From: Amber Willard
Sent: 03 September 2025 08:46
To: Planning.Responses
Subject: FW: BN/46/25/PL
Attachments: 230010_05B_proposedsiteplan-A1 SHEET.pdf; wandleys lane site plan.docx

BN/46/25/PL Wandleys Lane

I have received the transport assessment for Wandleys Lane which I attach above. They conclude that the proposed development served via a new access from Wandleys Lane presents no highway reasons for refusal.

**PROPOSED SITE PLAN
(1:200)**

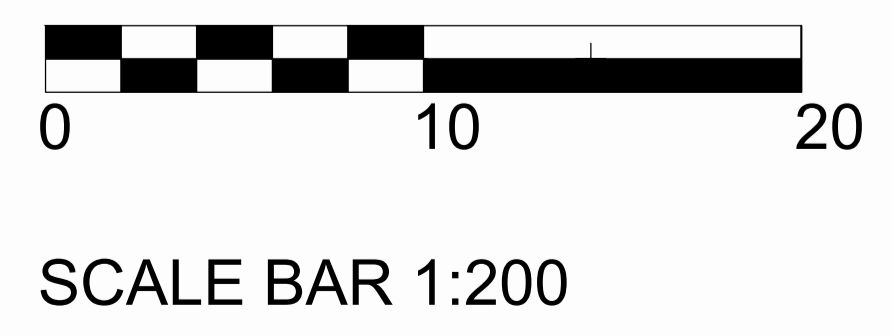
They have highlighted a slight discrepancy between the visibility splays that are shown on the site plans.

'The TS states that visibility splays of 2.4m x 43m are achievable at the site access, in line with the requirements set out in Manual for Streets (MfS) for a 30mph road such as Wandleys Lane. However, the site plan included at Appendix 1 of the TS states that the demonstrated visibility splays in the primary and secondary direction are shown as achievable to 2m x 43m.'

Are you able to provide a plan to demonstrate that splays of 2.4 x 43m are achievable. This can then be added to the list of approved plans.

Please see attached for the amended plan demonstrating the visibility splays of 2.4m x 43m. Darren is waiting for the report to be amended and then I will forward this through for consistency. Is there anything else you need?
